MONA OFFSHORE WIND PROJECT

Annex 3.3 to the Applicant's response to Relevant Representation at the Procedural Deadline

Applicant's Response to Relevant Representations from Natural Resources Wales (NRW): RR-011.89 to RR-011.97

Document Number: MOCNS-J3303-RPS-10222

**Figure 1.76: Figure A.3 of Volume 6, Annex 8.5: International and nationally designated landscape study (APP-105).**

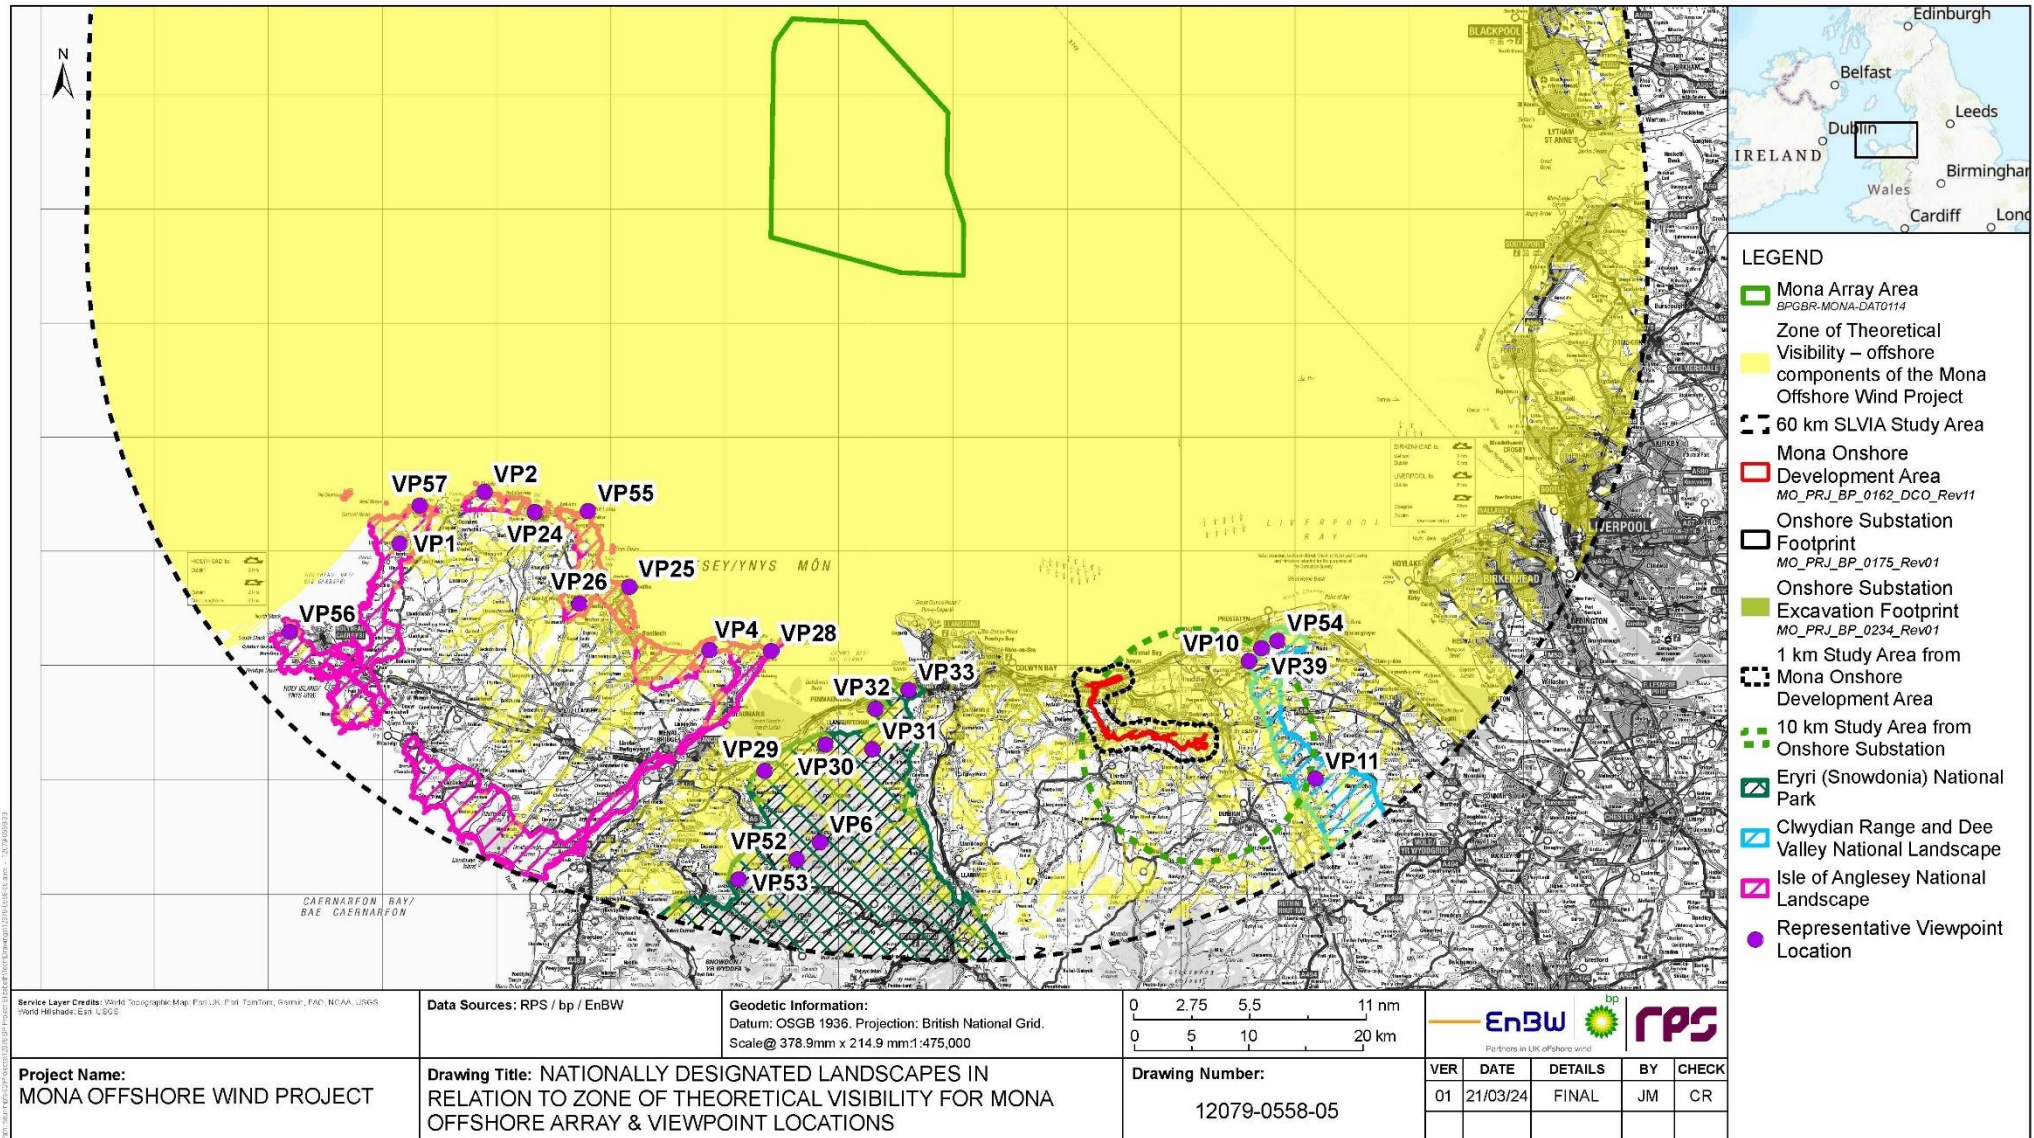
3.1.1.2 The changes above do not address concerns raised in pre-application advice provided by NRW to the applicant regarding the impacts of the proposed turbines on the IoA NL and potential cumulative impacts on both the IoA NL and ENP. Instead of reducing the maximum blade tip height of the turbines, the Applicant has increased it.

We advise that without a reduction in the height of the turbines and/or a reduction in the array area (i.e. away from the coast) it is likely the proposed turbines will cause

1.2.2.3 The Applicant's Zone of Theoretical Visibility (ZTV) for Isle of Anglesey NL is presented in Figure A.3: *Nationally designated landscapes in relation to zone of theoretical visibility for Mona Array Area offshore components and representative viewpoint locations*, in Volume 6, Annex 8.5 International and nationally designated landscape study (APP-105).

1.2.2.4 The Mona Array Area is located approximately 28.8 km from the Isle of Anglesey NL at the closest point at Point Lynas on the coast overlooking the Irish Sea. The theoretical visibility of the Mona Array Area (as shown in the ZTV) is primarily along the northeast coast of the Isle of Anglesey NL, as well as small areas of landscape near Holyhead and Rhoscolyn. The remainder of the Isle of Anglesey NL along southeastern, western and southern coastlines will be unaffected. The Applicant notes that the extent of actual visibility will be less due to screening afforded by intervening woodland and coastal settlements.

1.2.2.12 The Applicant's ZTV for Eryri NP is presented in Figure A.3: *Nationally designated landscapes in relation to zone of theoretical visibility for Mona Array Area offshore components and representative viewpoint locations*, in Volume 6, Annex 8.5 International and nationally designated landscape study (APP-105).
